From: Michael Rowland
Sent: 19 September 2018 13:33
To: Planning.Responses
Cc: Sue Howell
Subject: RE: Planning Consultation on: LU/241/18/PO

APPLICATION LU/241/18/PO

Site Address: Land at Courtwick Littlehampton BN17

Description of Works: Application for modification of planning obligation dated 22nd March 2012 under Planning application reference LU/355/10 relating to the Schedule 1 exemption clause & Schedule 2 truggaers & locations of LEAP/NEAP

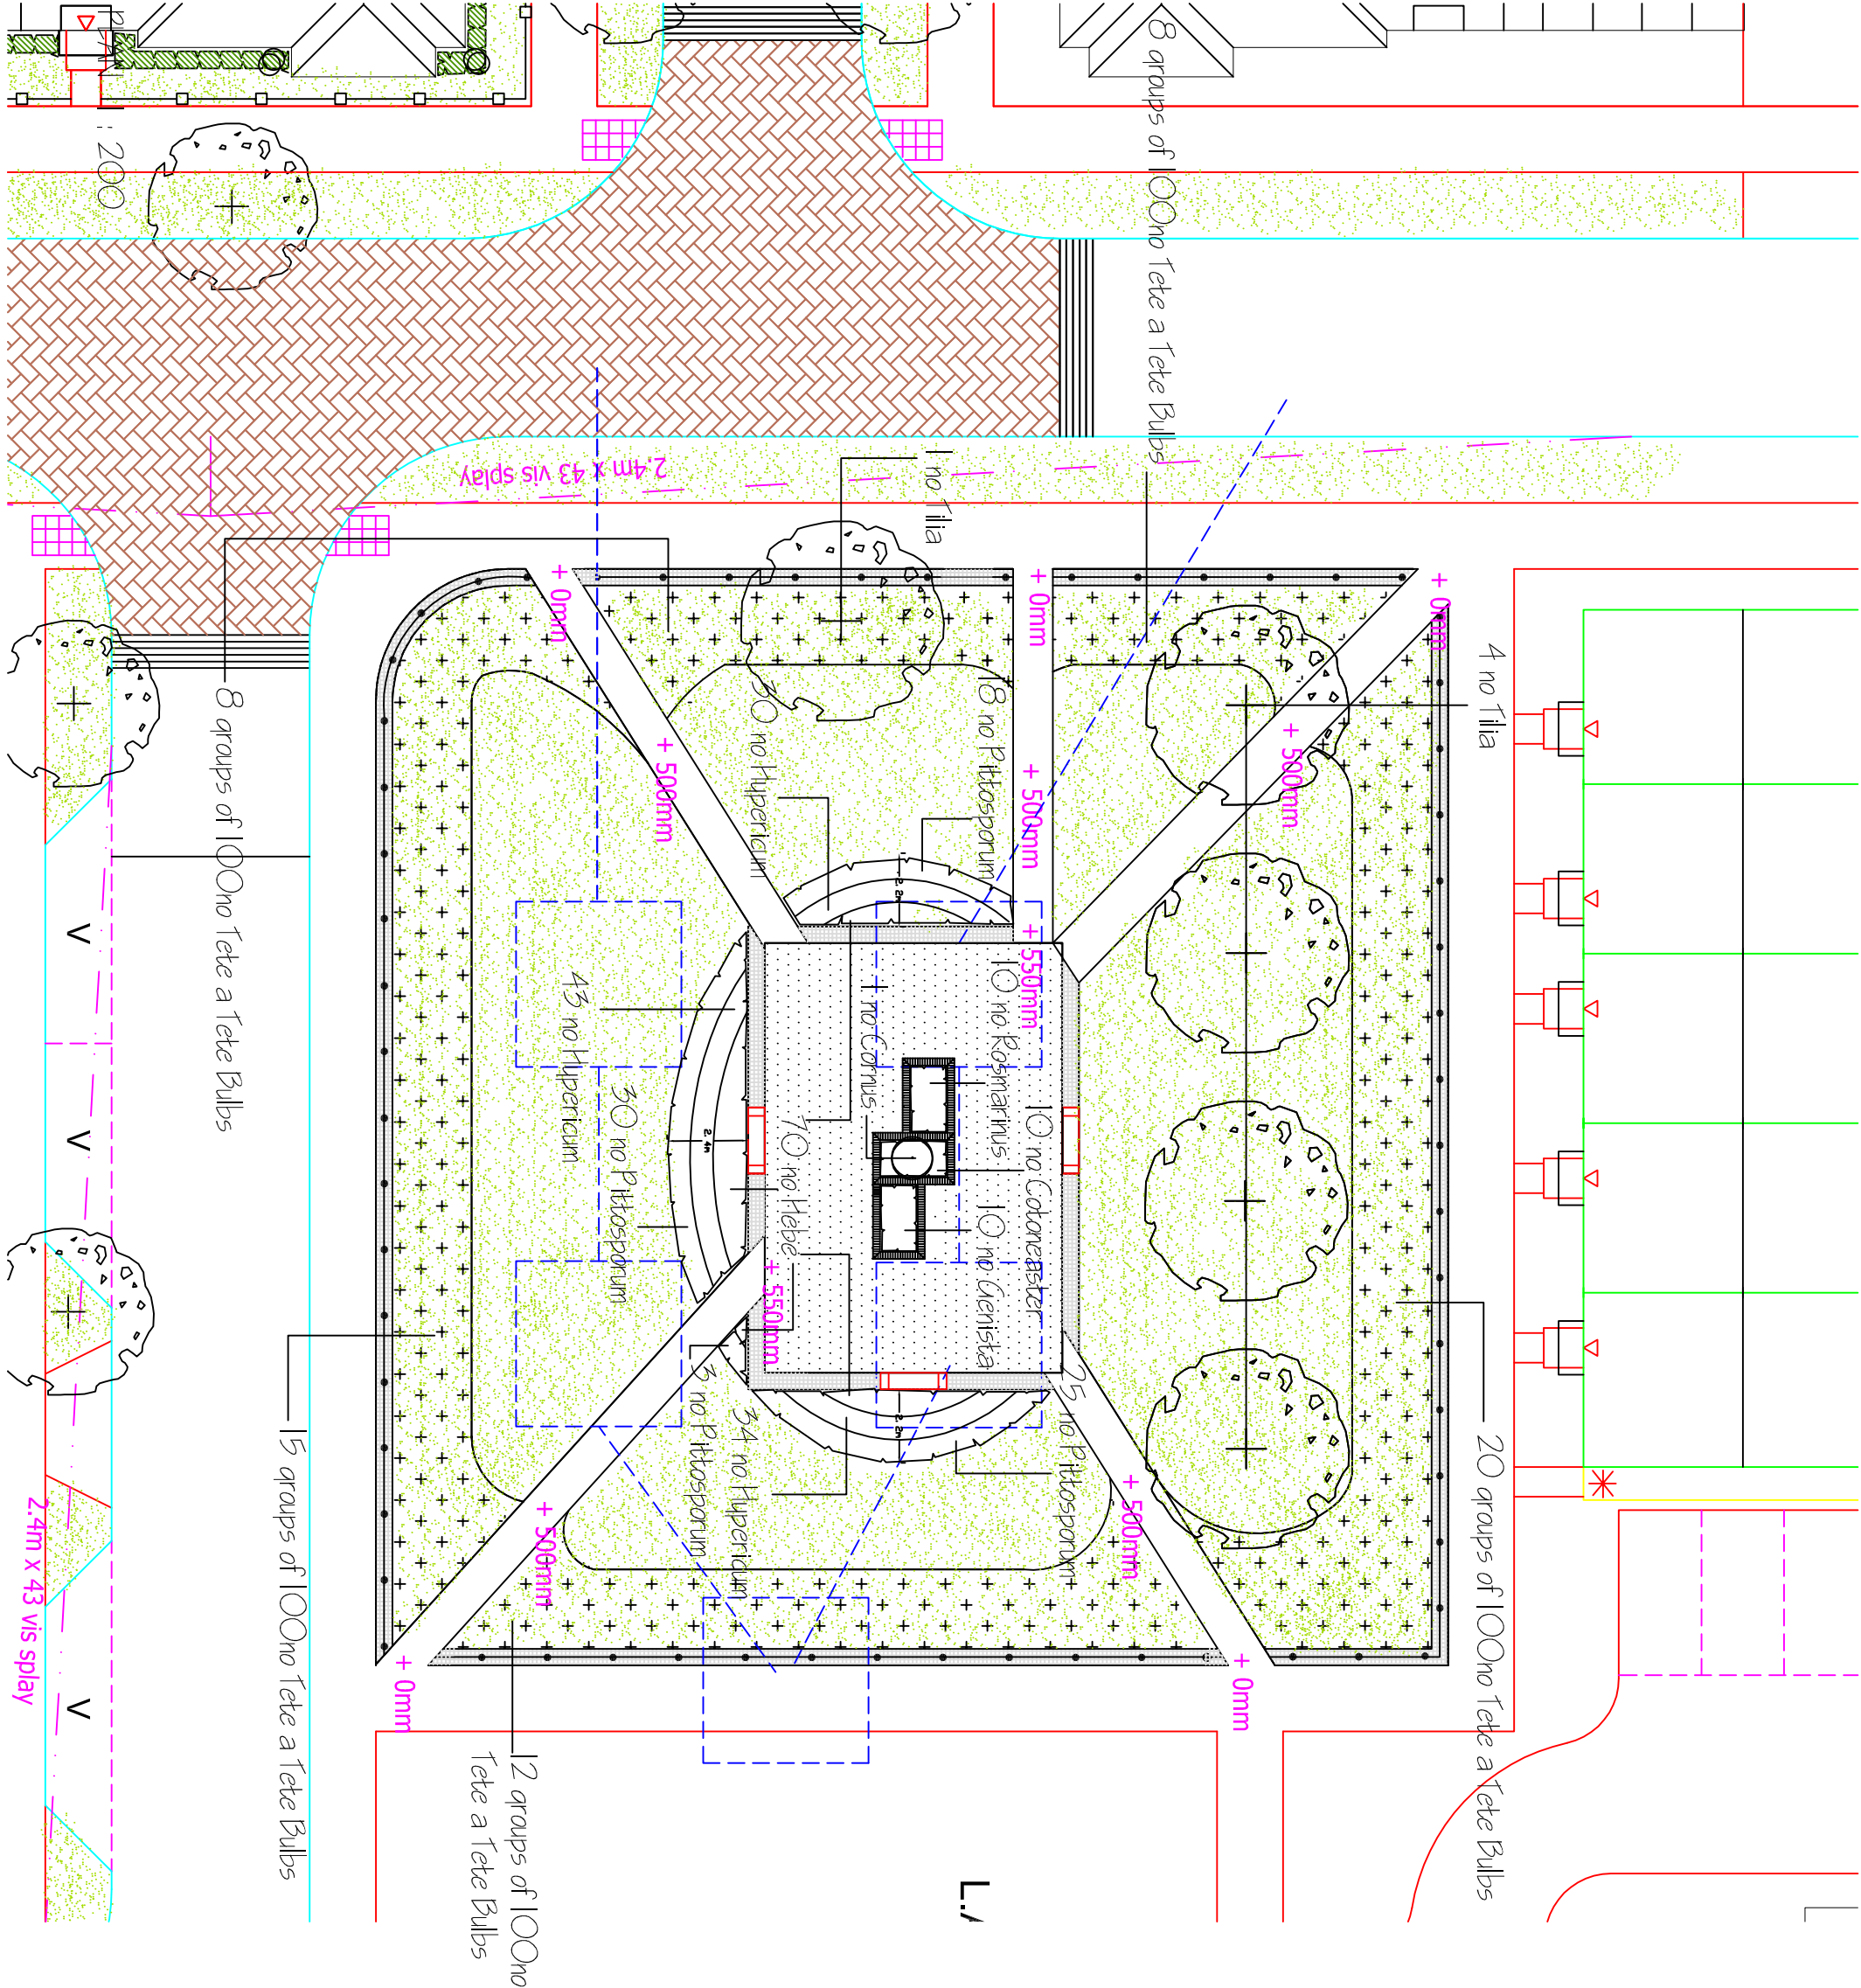
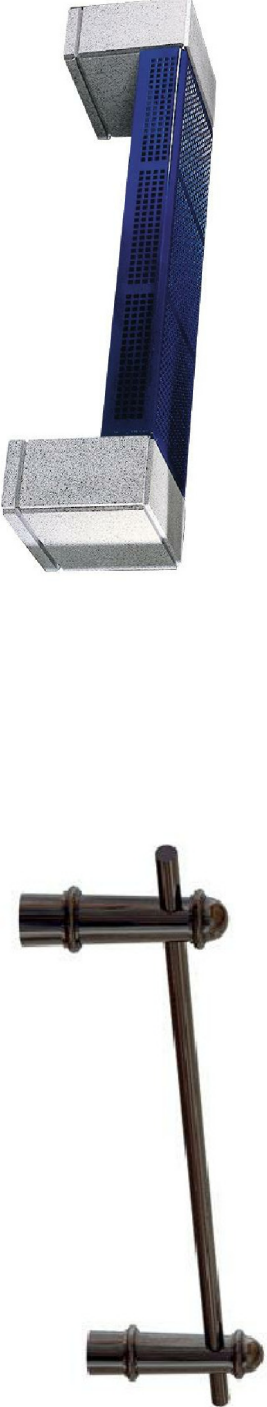
Having previously requested that the area, as detailed in the drawing *Central Square 972/07 E*, which was a originally proposed to be a play be re-specified as a landscaped area due to its proximity to residential properties I would like to comment with regard to the new proposal.

I find the proposed scheme acceptable except that I would recommend that the Royal Horticultural Society advice with regard to the planting of *Cotoneaster horizontalis* is followed:

“This plant [Cotoneaster horizontalis] is listed on Schedule 9 of the UK Wildlife & Countryside Act as an invasive non-native species. While this does not prevent it from being sold in the UK, or from being grown in gardens, the RHS encourages those that do grow it to take great care with managing it and with disposing of unwanted material. The RHS also encourages gardeners to find alternative plants to grow to those listed on Schedule 9. For suggested alternative plants see the Plantlife/RHS guide: Gardening without harmful invasive plants”
